CITY OF ALBUQUERQUE

RE: 9519 Lyndale Lane NW
Grading and Drainage Plan
Engineer's Stamp Date: 08/04/21
Hydrology File: C13D027F

Based upon the information provided in your submittal received 08/09/2021, the Grading & Drainage Plan **is not** approved for Grading Permit. The following comments need to be addressed for approval of the above referenced project:

A GRADING AND DRAINAGE PLAN
FOR PROPOSED
ARTURO DE LA O RESIDENCE
9519 LYNDALANE N.W.
ALBUQUERQUE, BERNALILLO COUNTY, NEW MEXICO
JULY, 2021

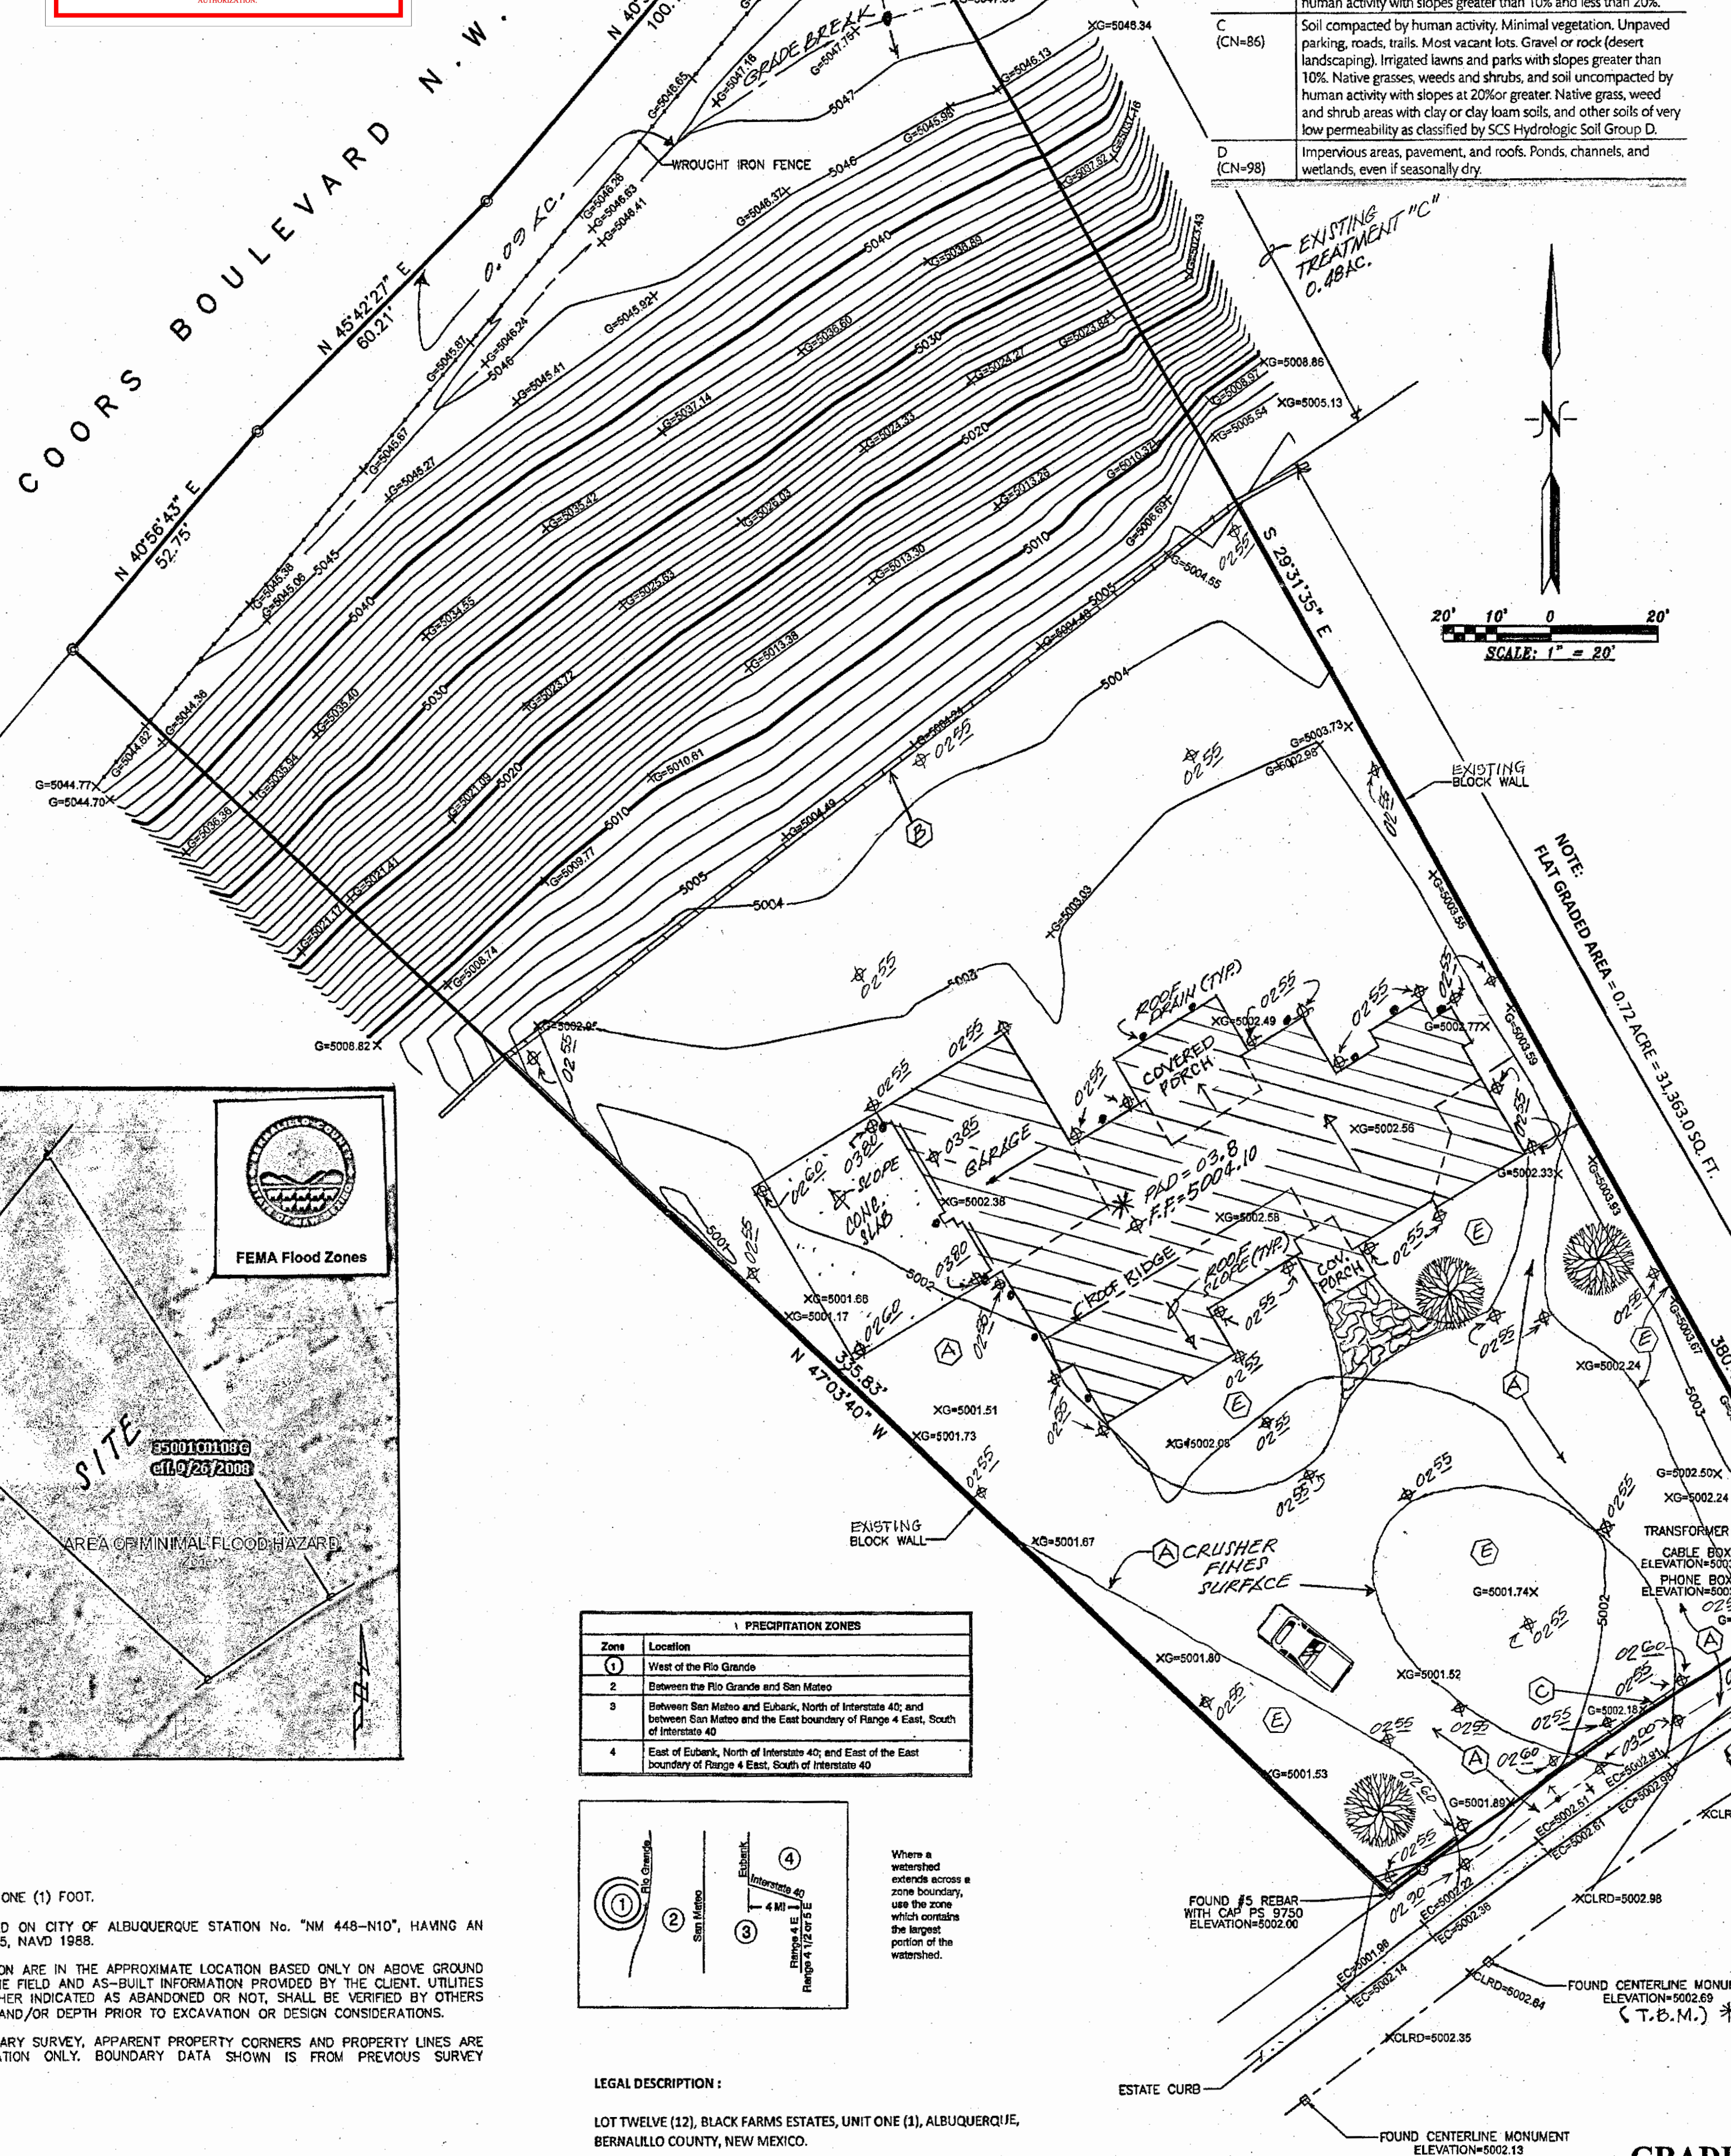
1. This lot is part of the Drainage Report for Black Farms by Tierra West dated June 2004 (C13D027). This drainage report states that each lot is required to follow the Flat Grading Scheme of the DPM. Please note that you must follow the current DPM Article 6-5 Valley Drainage Criteria and pond the 100 year 10-day volume. Below are excerpt of the Drainage Report. According to the report for this lot, the required retention volume is 0.21 AC-FT or 9,147.6 CF of volume.
